Our Ref: LU/421/17/HH
Your Ref:

Town & Country Planning Act 1990 (as amended)
Town & country Planning (Development Management Procedure) (England) Order 2015
Application for Planning Permission for Works or Extension to a Dwelling

Development Retention of covered lean-to on rear elevation.
Location 16 Maxwell Road Littlehampton

BLOCK/SITE PLAN AT SCALE 1:200

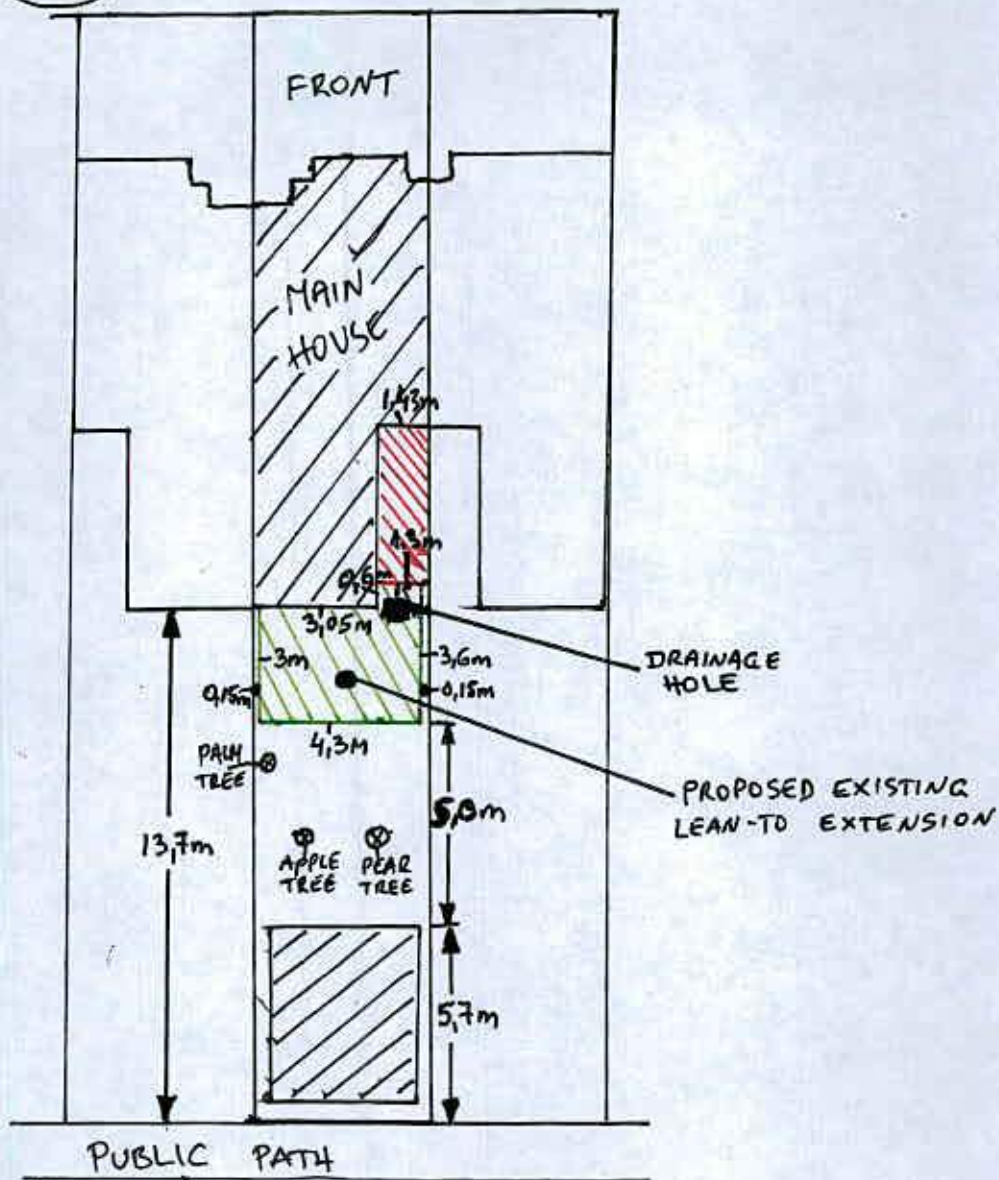
Block Plan Amend

Please submit 1 electronic or 3 paper copies of a block/site plan at a scale of 1:500 or 1:200. Further details of what must be included on the plan can be found in the National Validation Requirements. Please provide a measurement from the rear of the lean-to to the back boundary.

EXISTING & PROPOSED ELEVATION PLANS

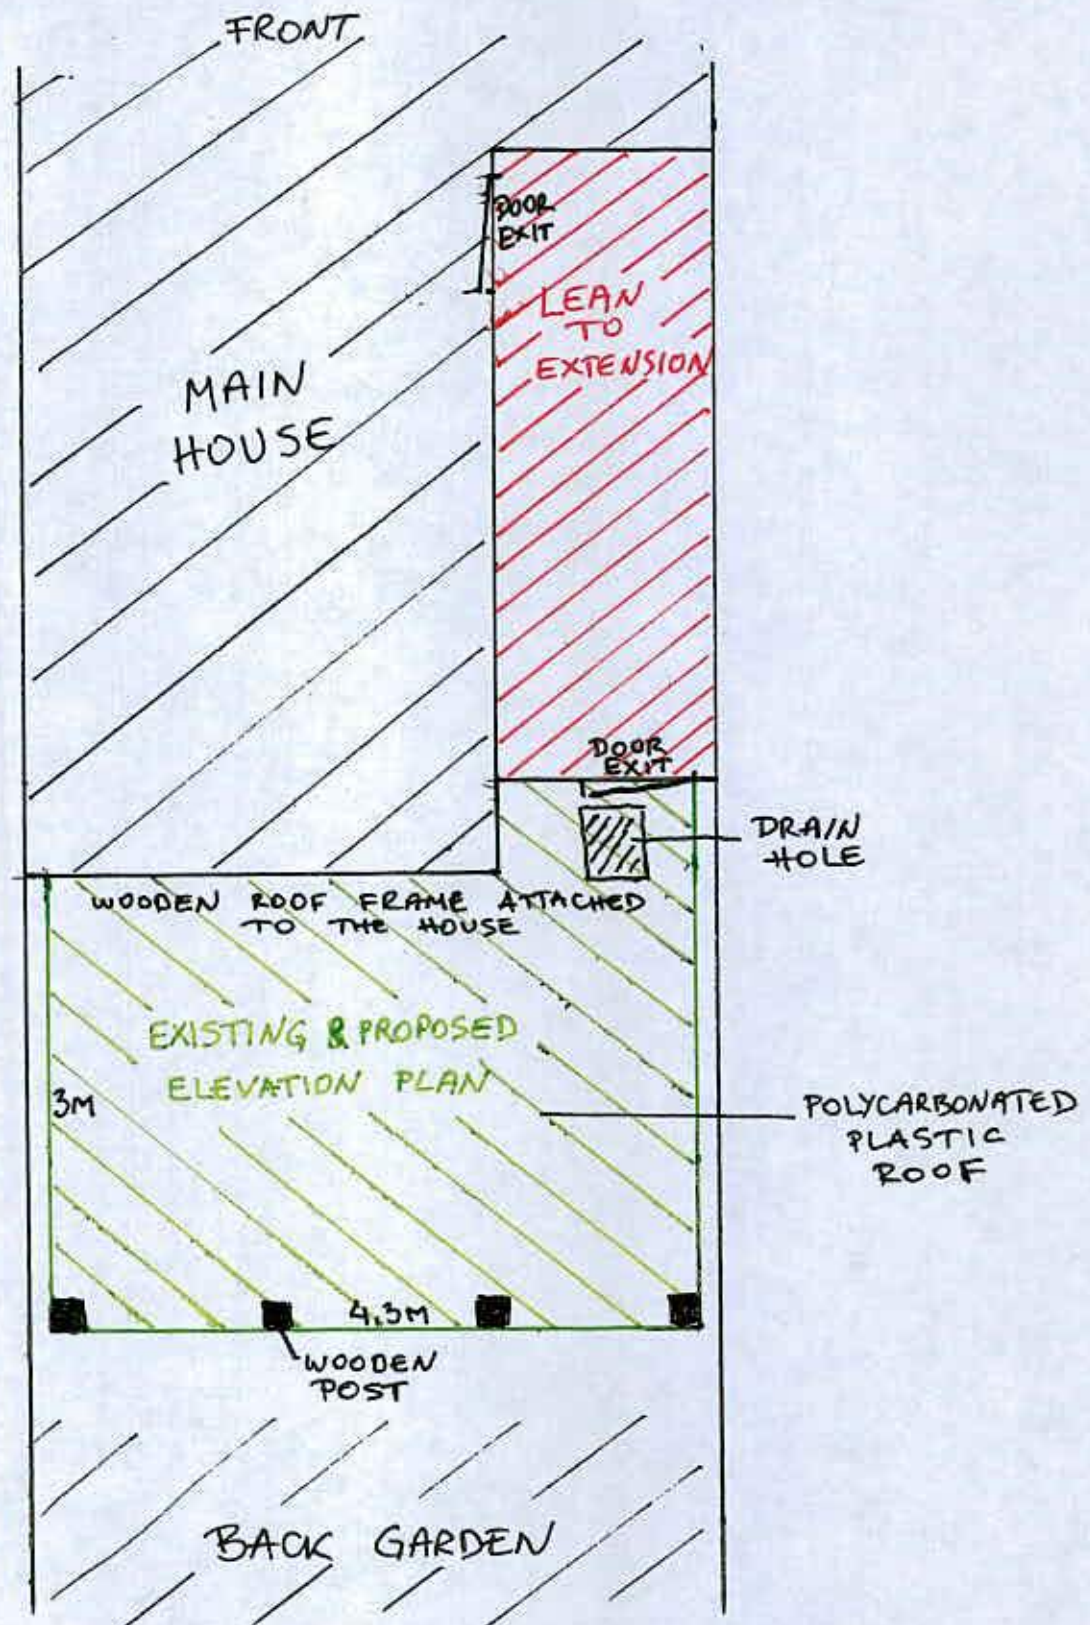
Elevations

Please submit 1 electronic or 3 paper copies of clearly labelled existing and proposed elevations at a scale of 1:50 or 1:100. Further details can be found in the National Validation Requirements.
